# BARBARICK RECYCLING AND REFUSE TRANSFER STATION

CONSTRUCTION DOCUMENTS  
MARCH 2024

BARBARICK WASTE TRANSFER STATION  
EL PASO COUNTY, COLORADO  
CONSTRUCTION DOCUMENTS  
COVER SHEET

SHEET L7.1

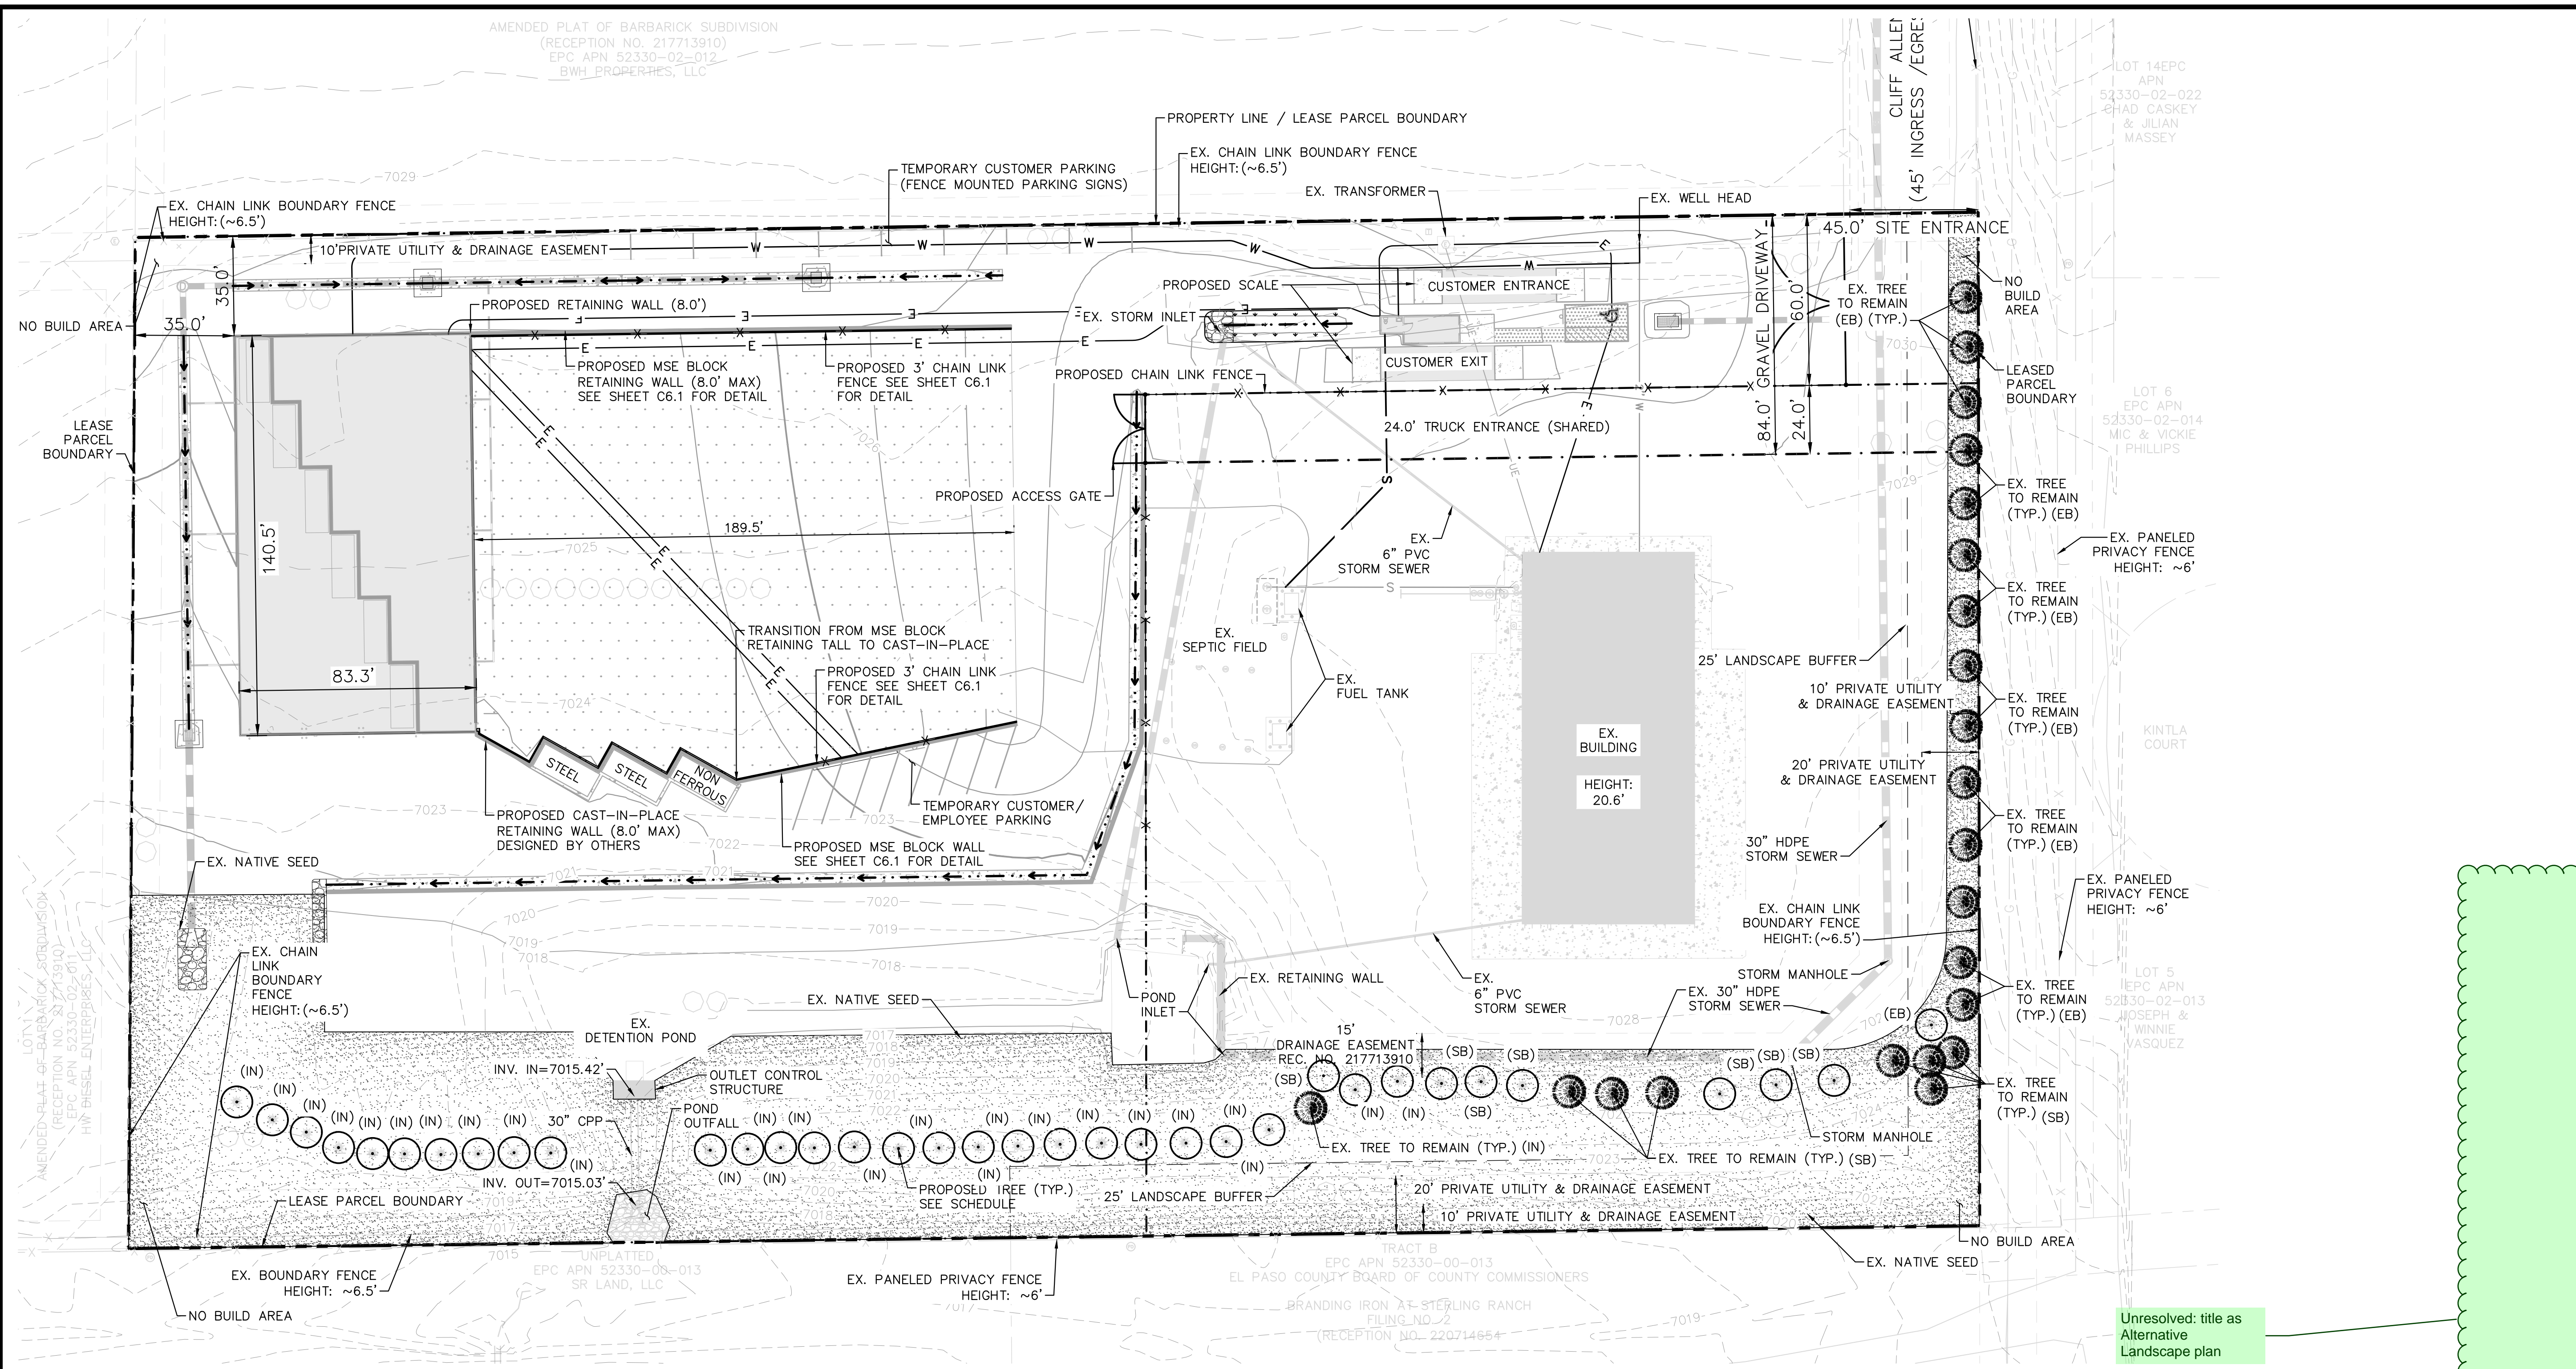
Please remove items from Section 3 since they are improvements for a single lot.
